Waynflete
School

Waynflete School Middle School Facility Addition
Conditional Use/ Site Plan Review – Final Submission

PLANNING BOARD REPORT #24-99

**BUILDING ADDITION CONNECTING 338 AND 342 SPRING STREET
CONDITIONAL USE, SITE PLAN AND HISTORIC PRESERVATION REVIEW
WAYNFLETE SCHOOL, APPLICANT**

North Elevation Study SPRING STREET

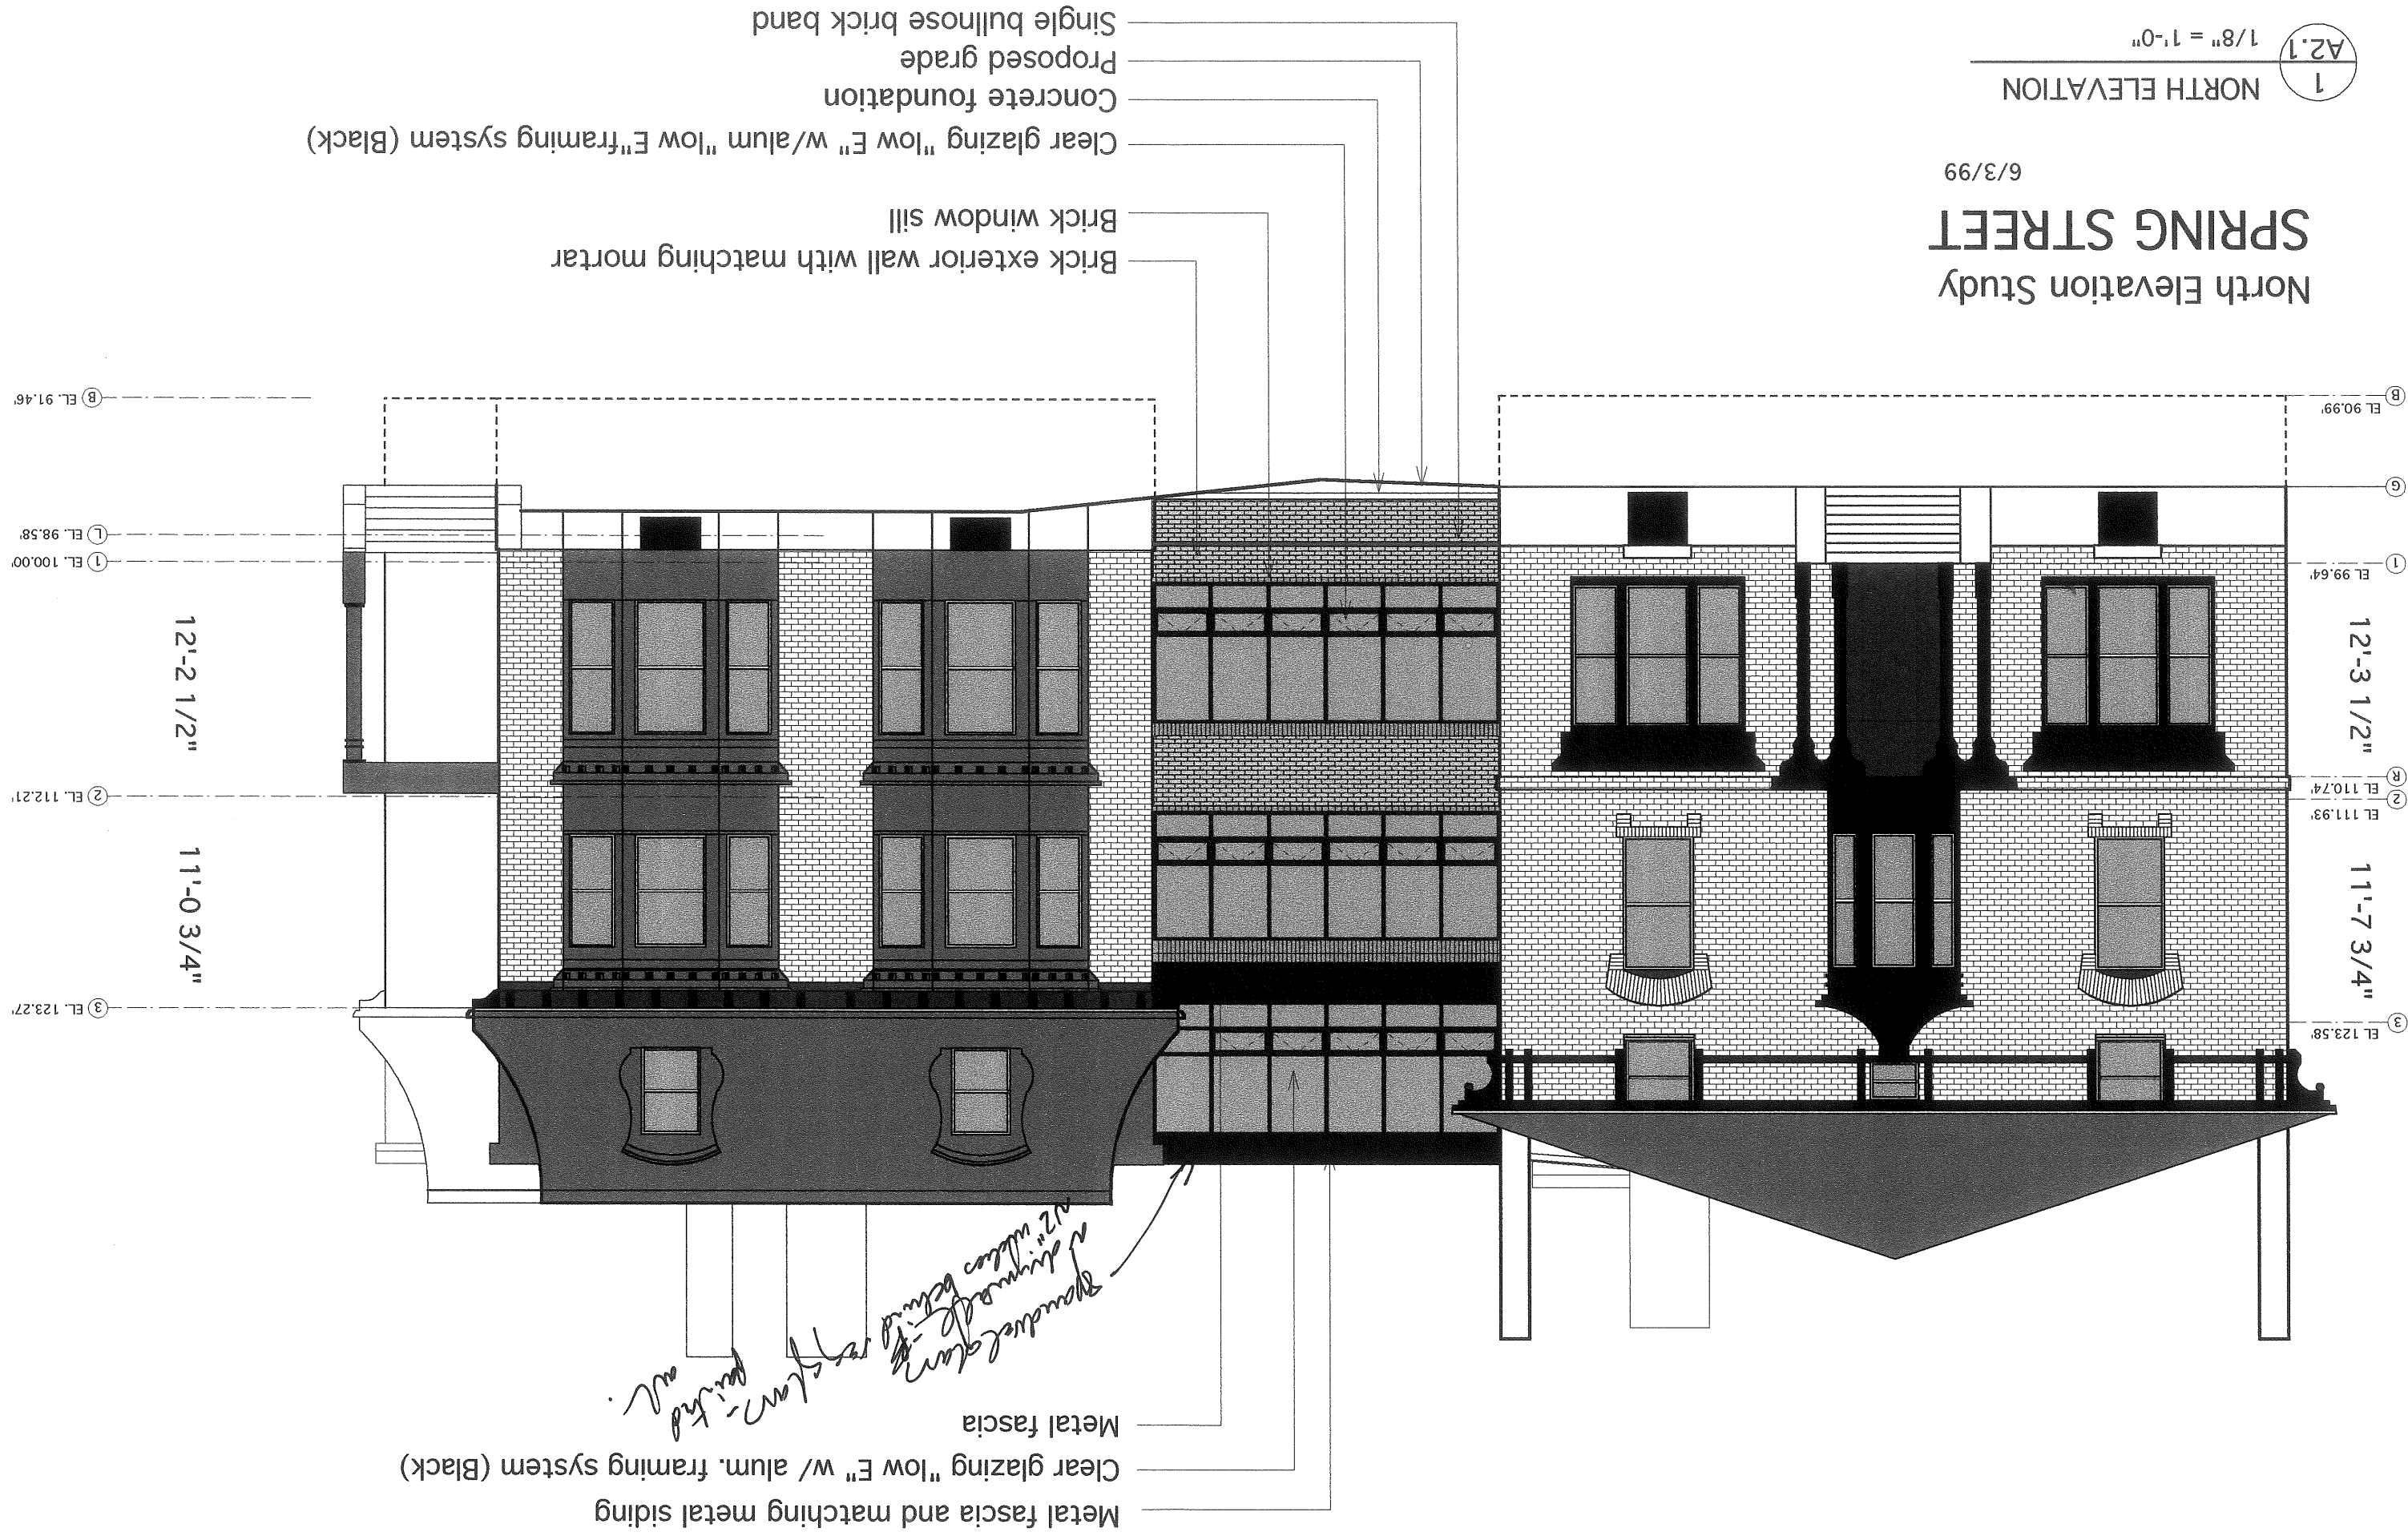
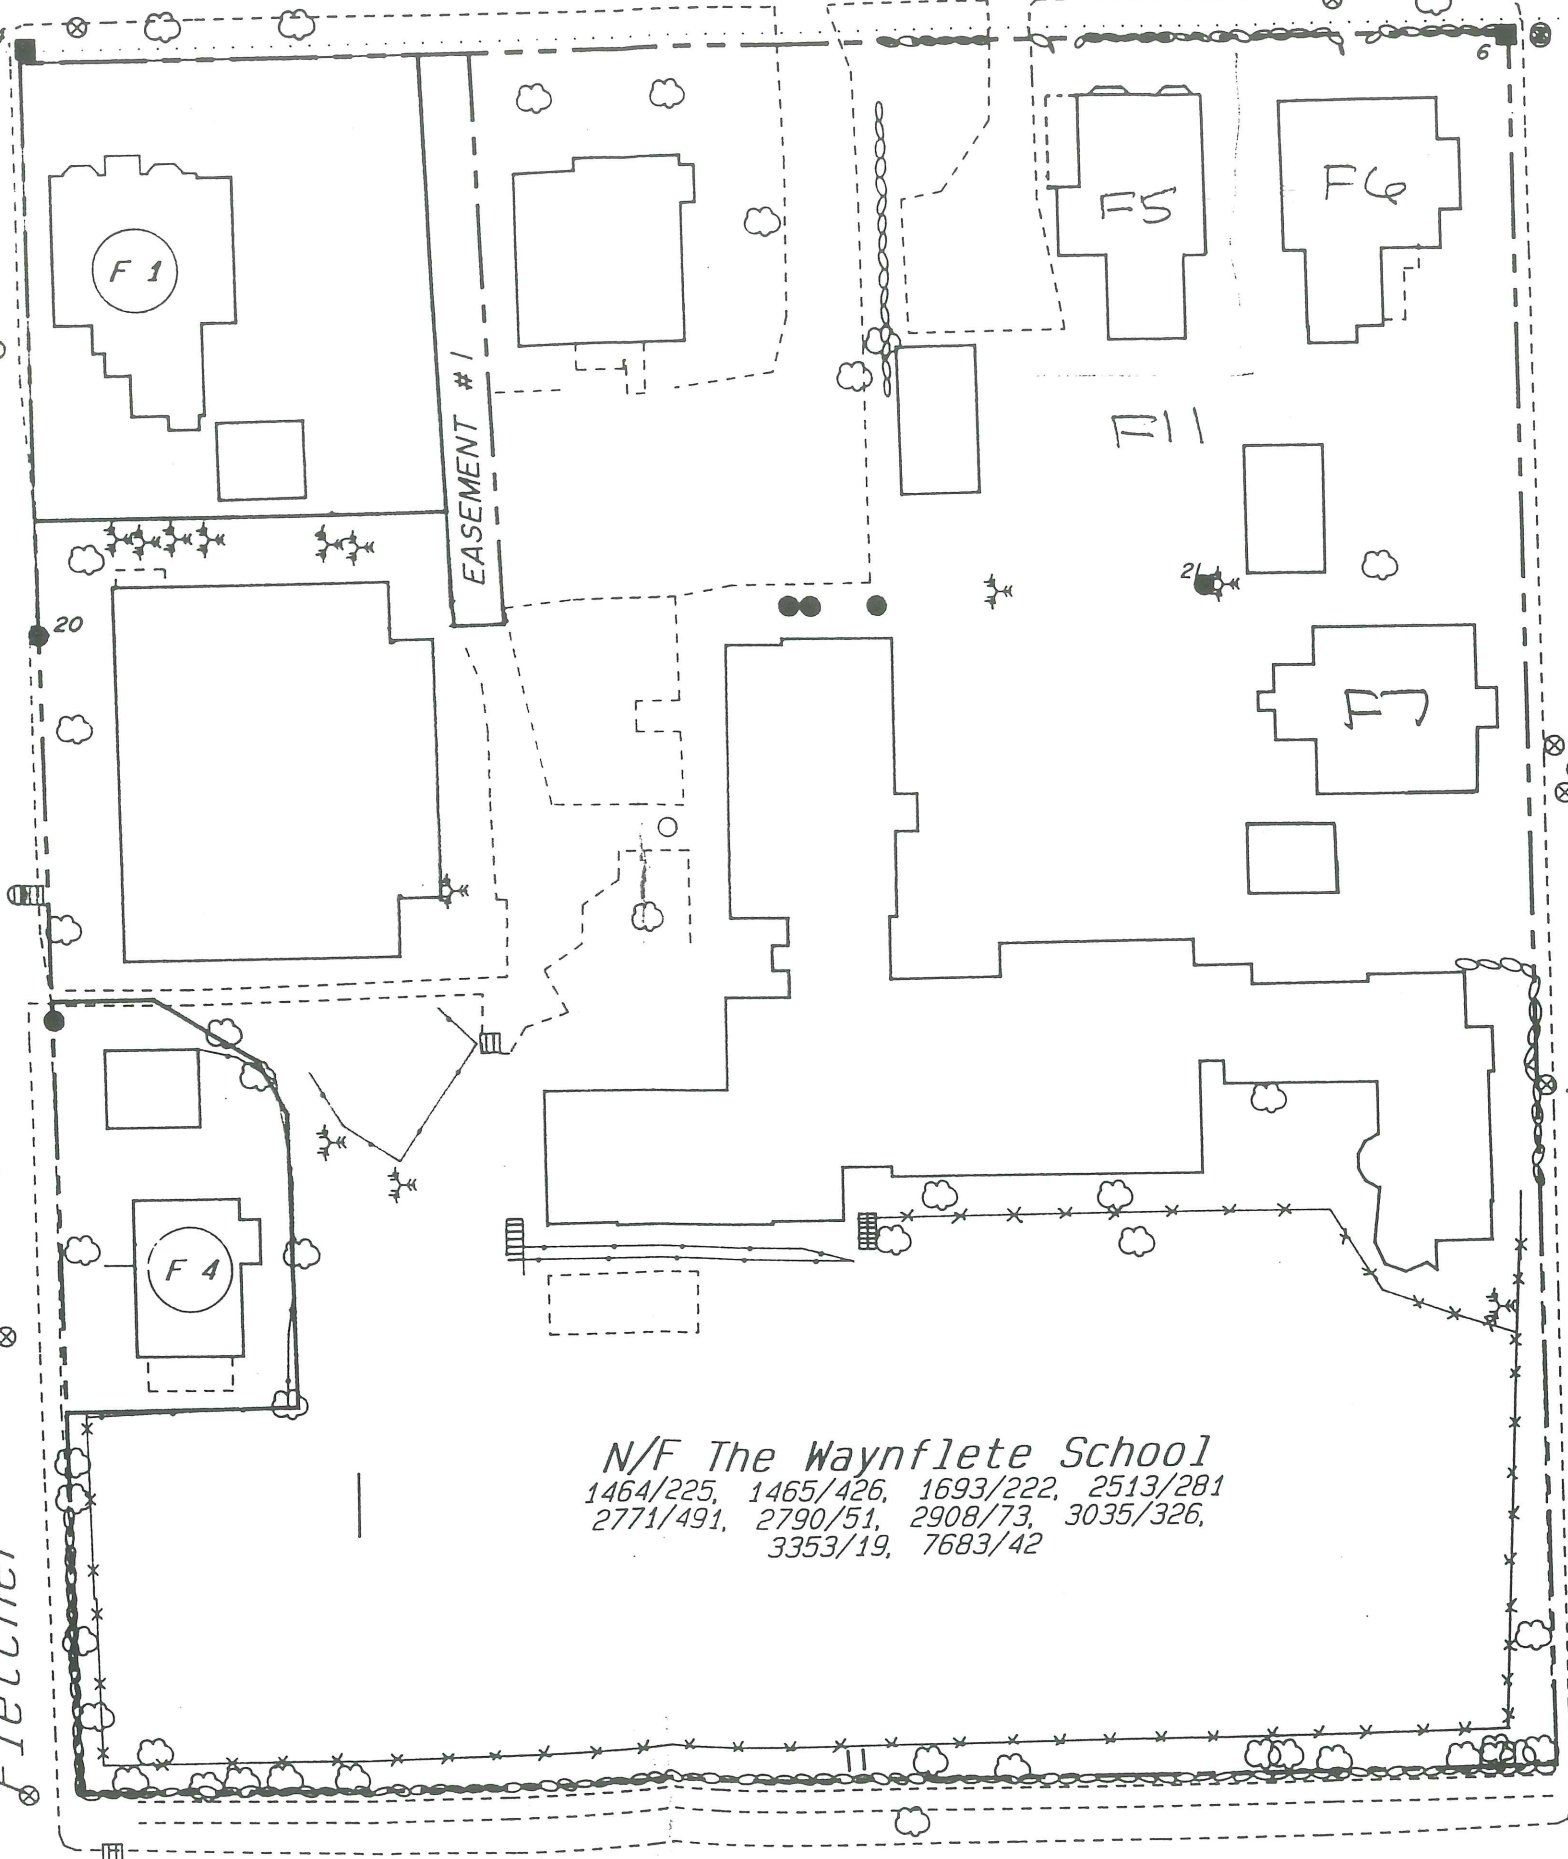
- * That the brick proposed for the Spring Street facade be Morin's "All Black" Old Port blend, which was presented as an option at the meeting. Mortar to be tinted dark gray with concave tool joints. Staff to review and approve test patch prior to commencement of final bricklaying.
- * Plans may be revised to feature operable windows on the Spring Street facade, provided such windows are installed across the entire width of each floor to ensure visual consistency. (It is understood that the overall design of the window will remain essentially the same.) A detail showing the revised windows shall be submitted to staff for final review and approval.
- * That the windows proposed for the Spring Street facade be non-reflective and untinted.
- * That the aluminum window frames feature a painted, as opposed to anodized, finish.
